Your ref:
Our ref: 21/00122/F
Please ask for: Mrs Rebecca Bush
Direct dial: 01553 616825
Direct fax: 01553 616652
E-mail: borough.planning@west-norfolk.gov.uk

5 February 2021

Details: **Construction of two storey extension connecting to existing cottage's West end at ground and first. New extension predominantly timber clad under a pan tiled roof, with timber windows throughout. Modest modifications to single storey lean-to at West end of cottage, minor internal modifications and enhancements, removal of existing timber shed and oil tank, and modest, localised adaptations to hard landscape. at Denning 7 Marsh Lane Burnham Norton Norfolk PE31 8DS**

SECTION B FACING NORTH, THRO' LOGGIA
1:100 @ A1

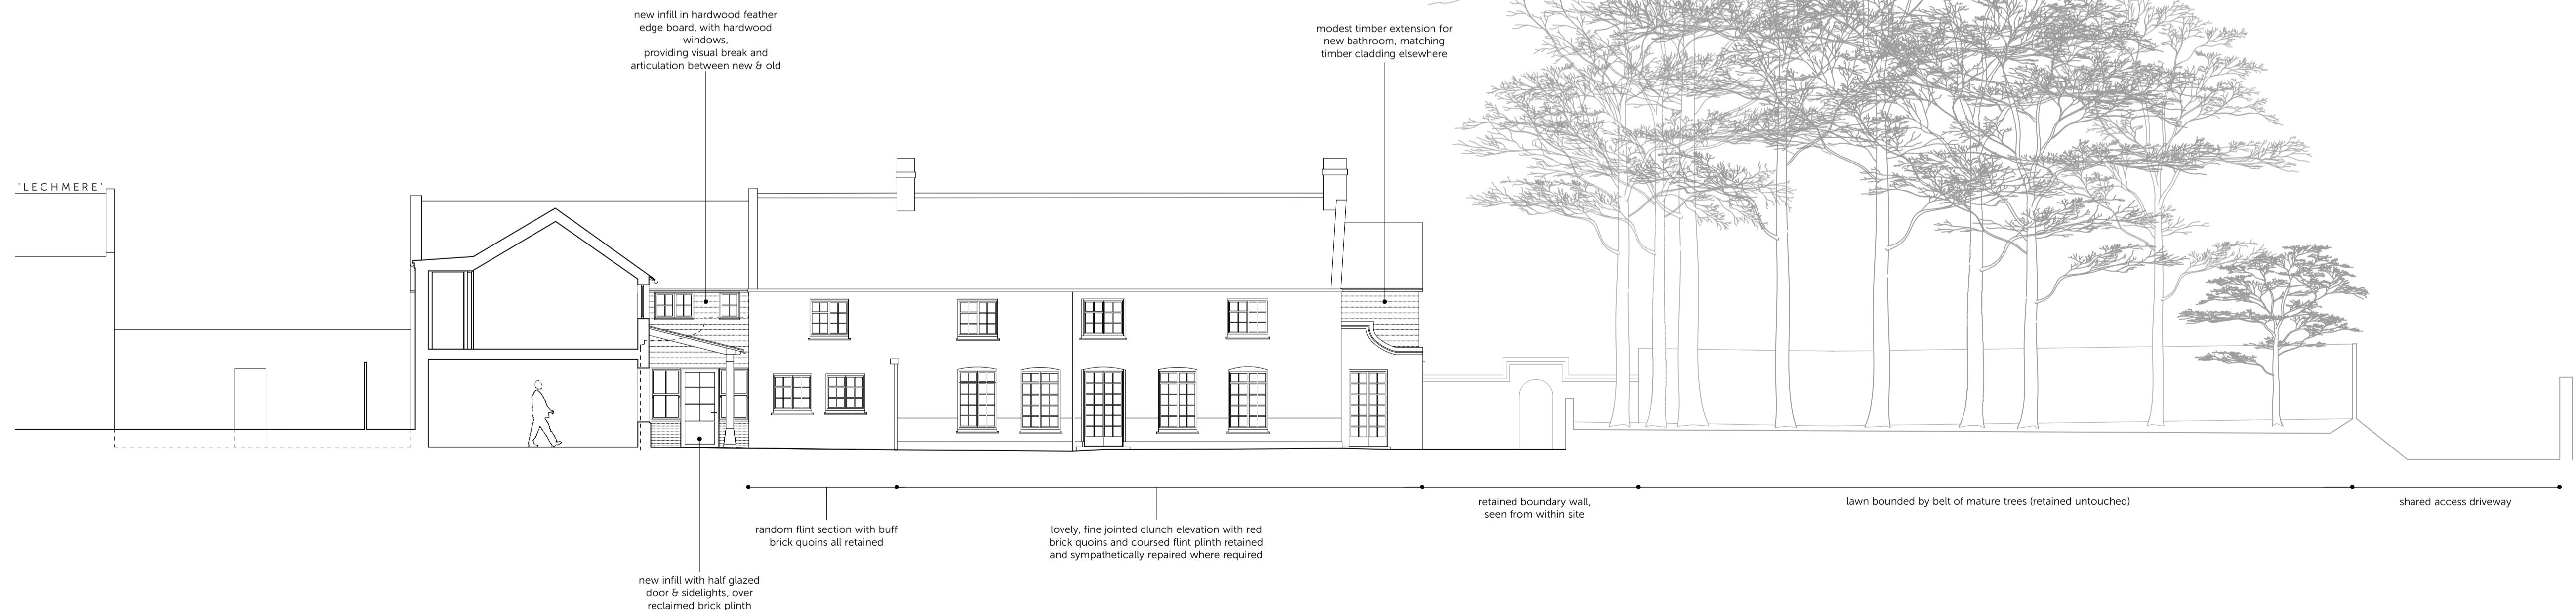
1. There appears to be a window missing on the first floor of the Section B facing North elevation on P111 Rev P4. Please amend.
2. As the property lies within an area at risk to flooding, please complete the simplified Matrix and return it. The Matrix can be found at https://www.west-norfolk.gov.uk/info/20173/information_for_planning_agents/231/flood_risk_information
